FERN 20026497 input to ExA questions to the Applicant on Two Village Bypass

Sarah Green for FERN

2) Applicants answers to EDF's questions and some FERN comments in RED

**DRAWING TITLE:**  
 TREE ROOST INSPECTION RESULTS -  
 TWO VILLAGE BYPASS  
 SHEET 3 OF 3

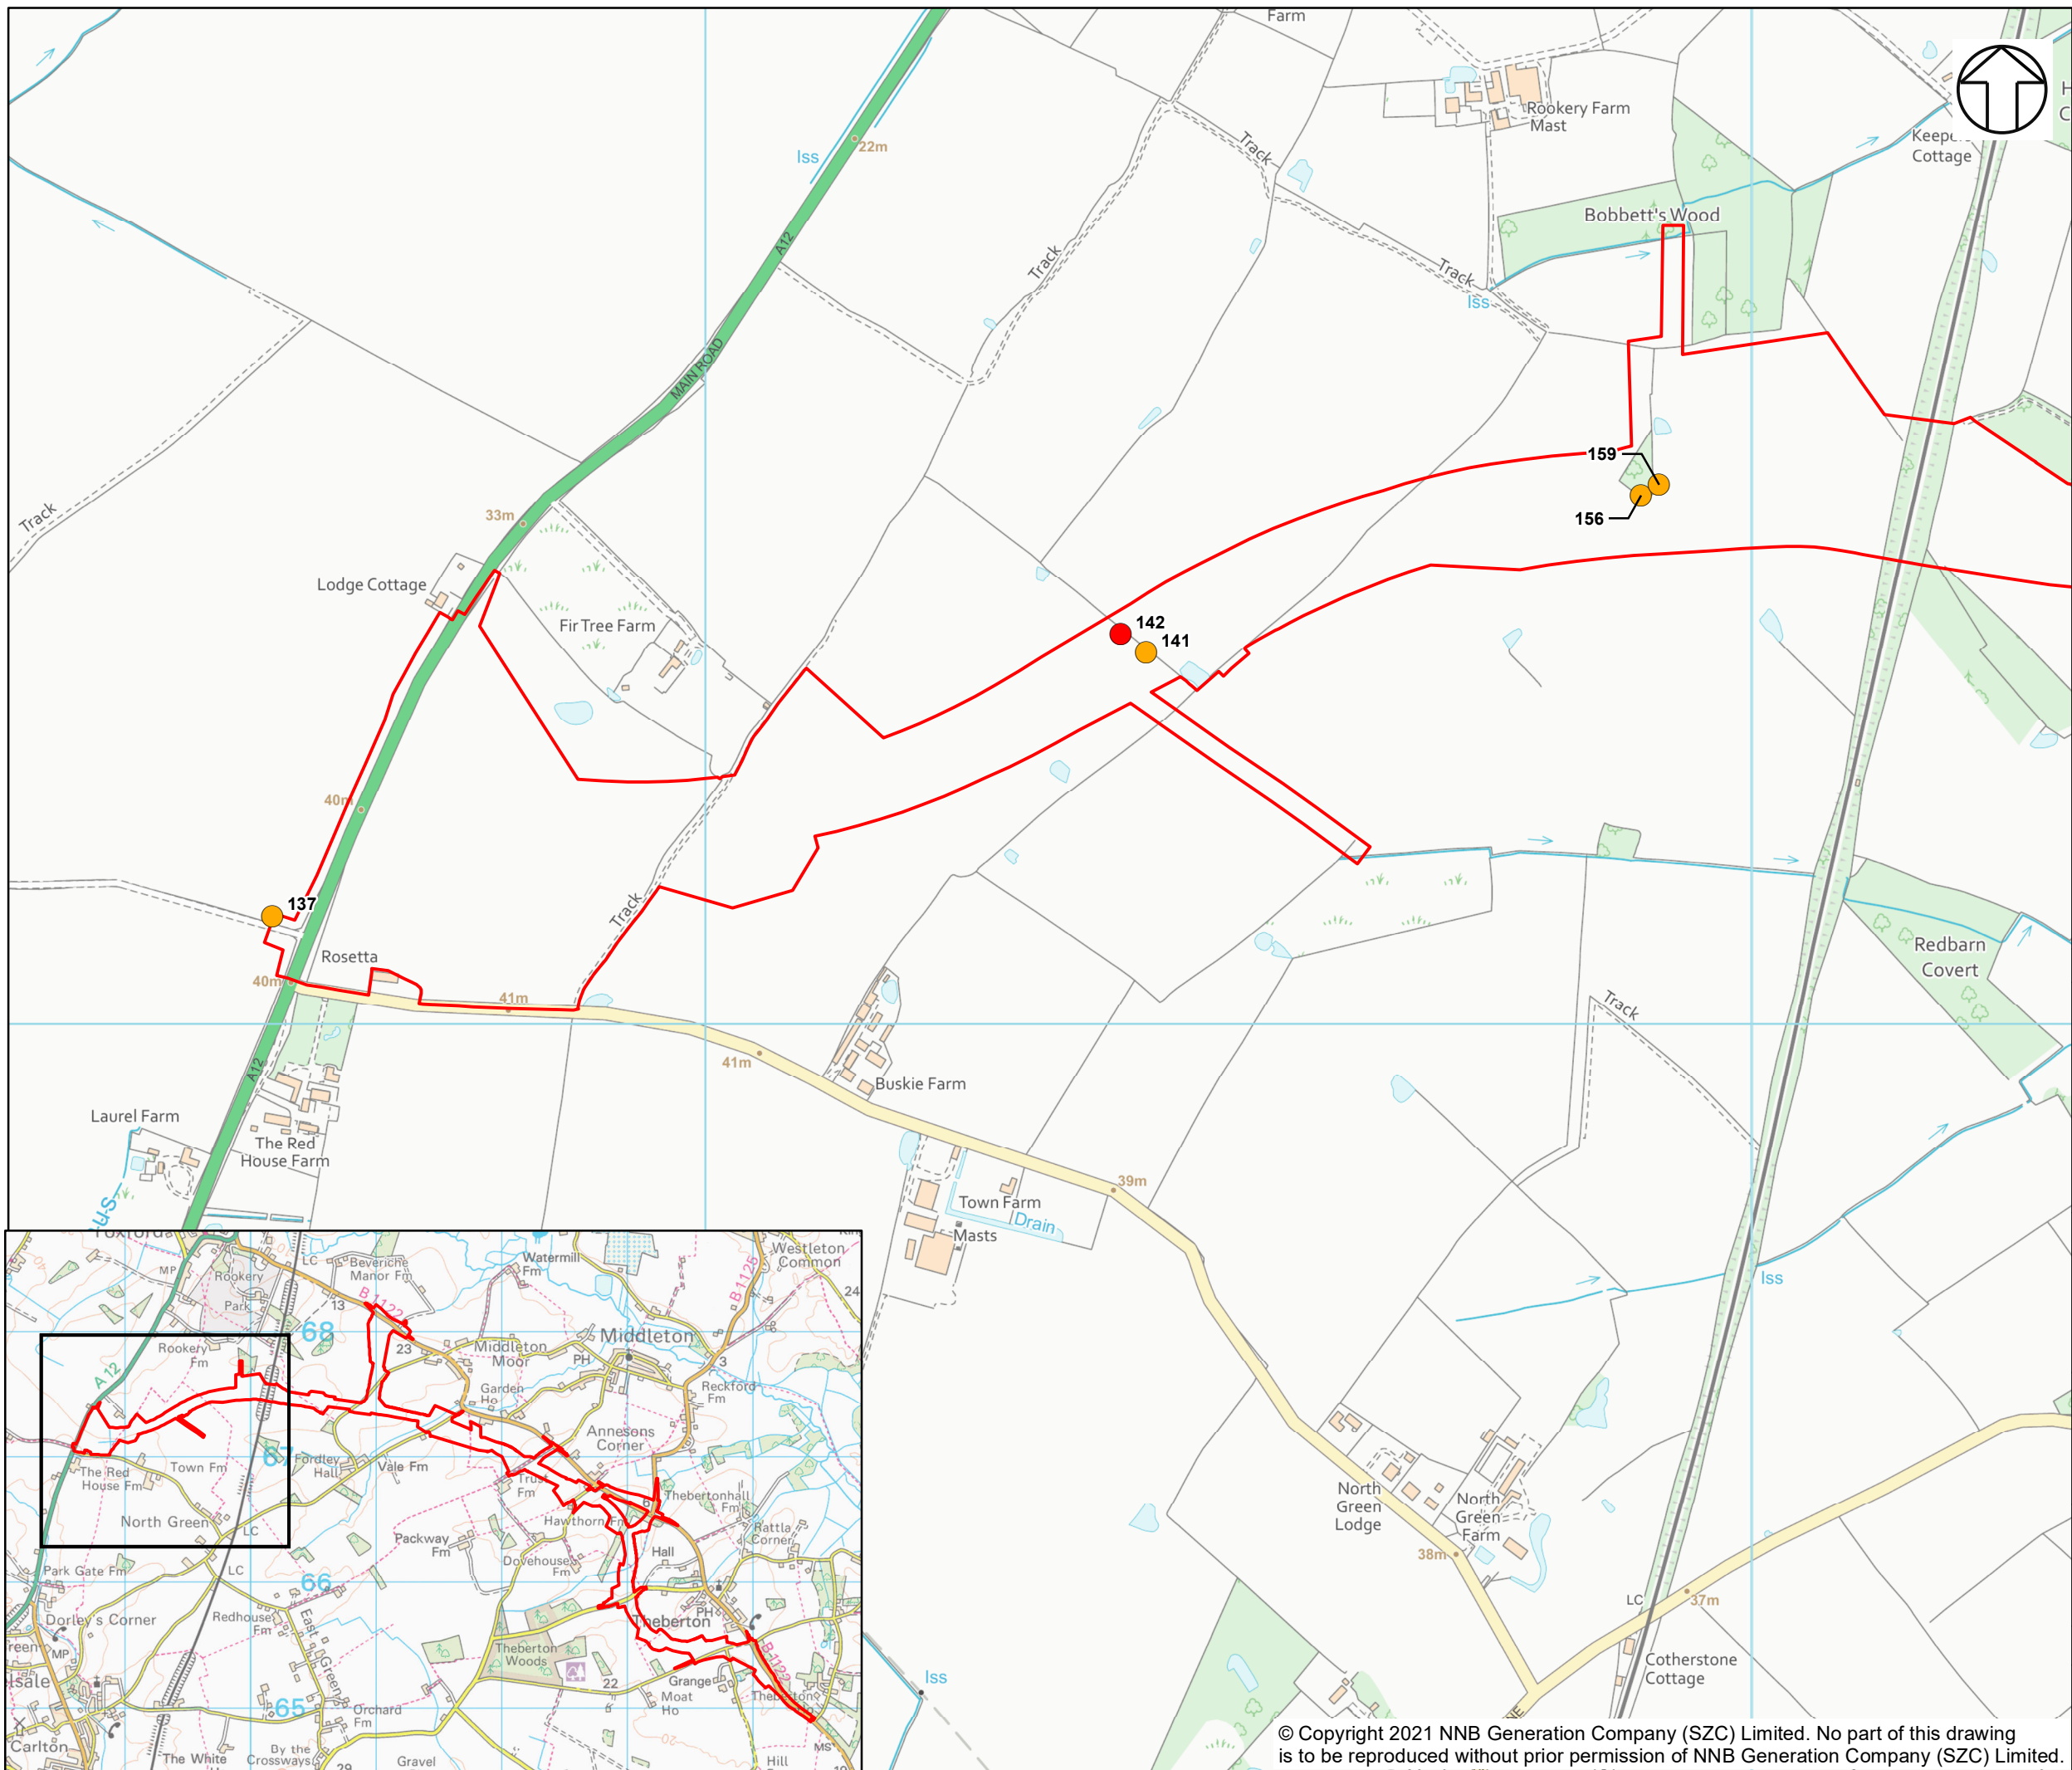
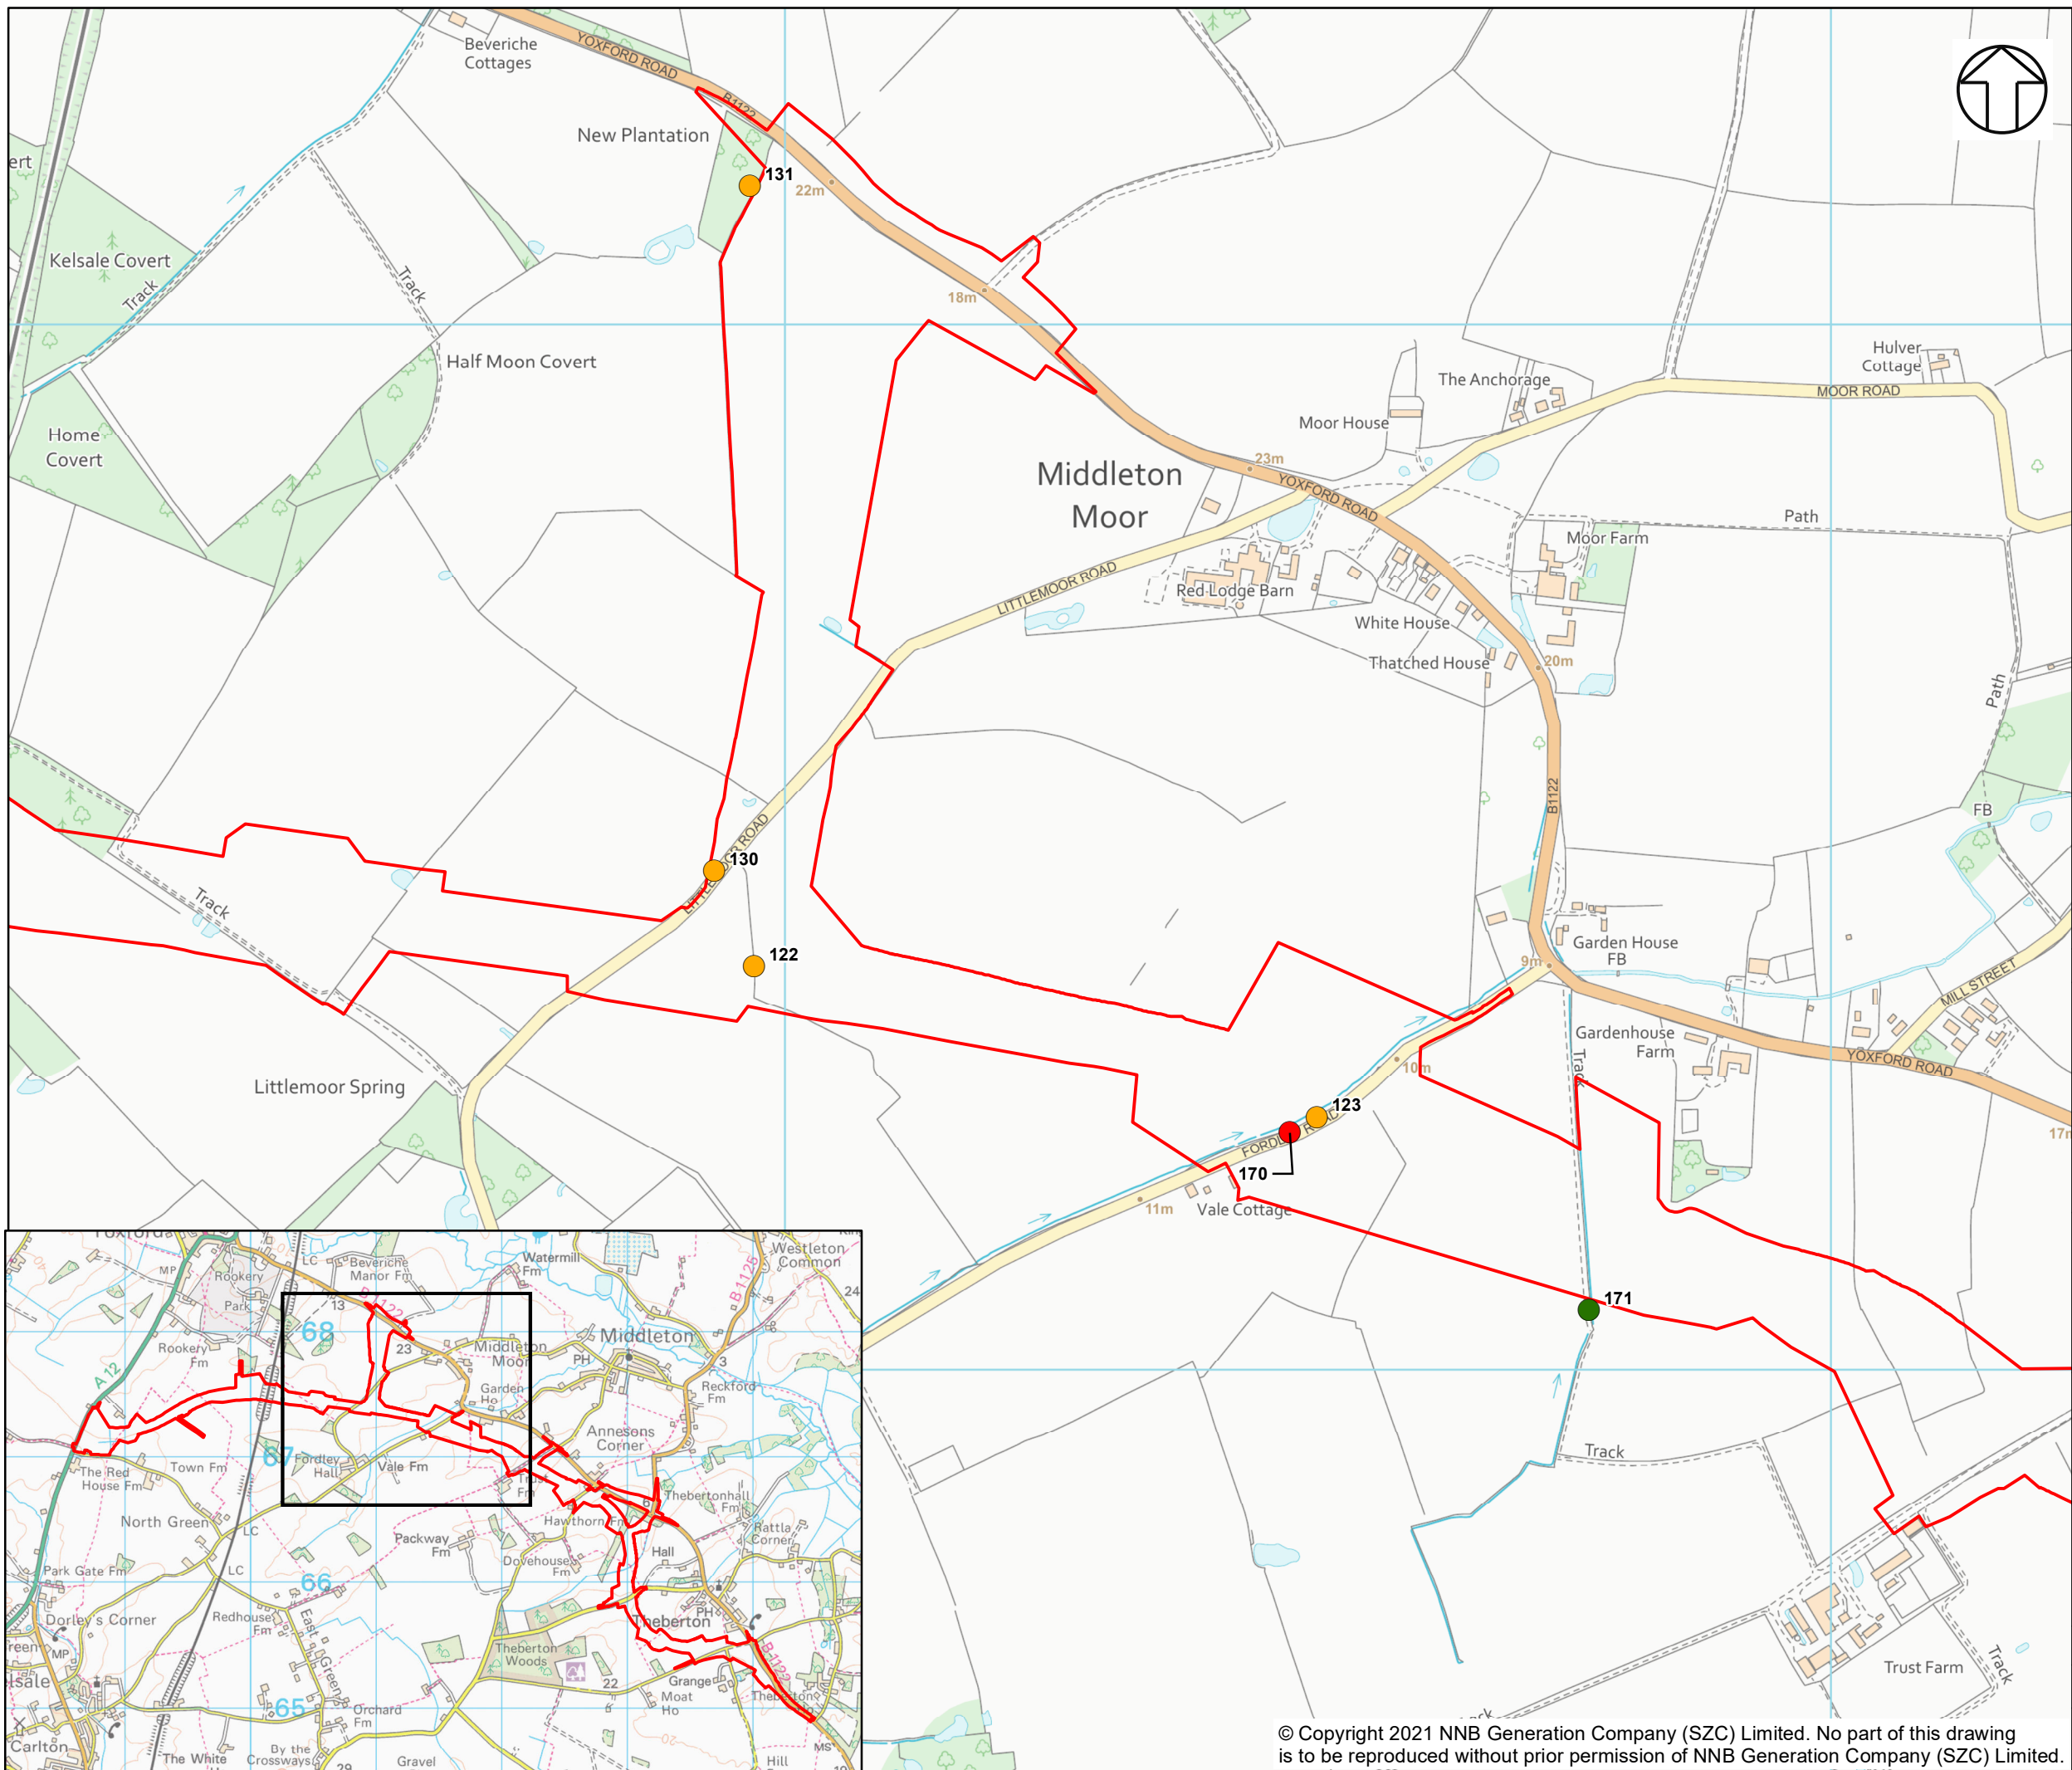
ii) Bat roost surveys, although Jake confirmed they had finally been done but only on Mr. Latham's land (the farmer who appears to benefit from much surveying, unlike FERN members). FERN has repeatedly asked for proper bat surveys to include the sites mapped below that are adjacent to EDF's site. The red line Ancient Wildlife Corridor is where the greatest bat activity is recorded, yet ecologists have failed to survey properly where these bats come from, ignoring listed maternity roosts and other ancient trees adjacent to their site.

- Listed maternity bat roosts Booths Barn & 2 Farnham Barn
- Grove of Listed Ancient/Veteran trees
- Ancient Hedgerow
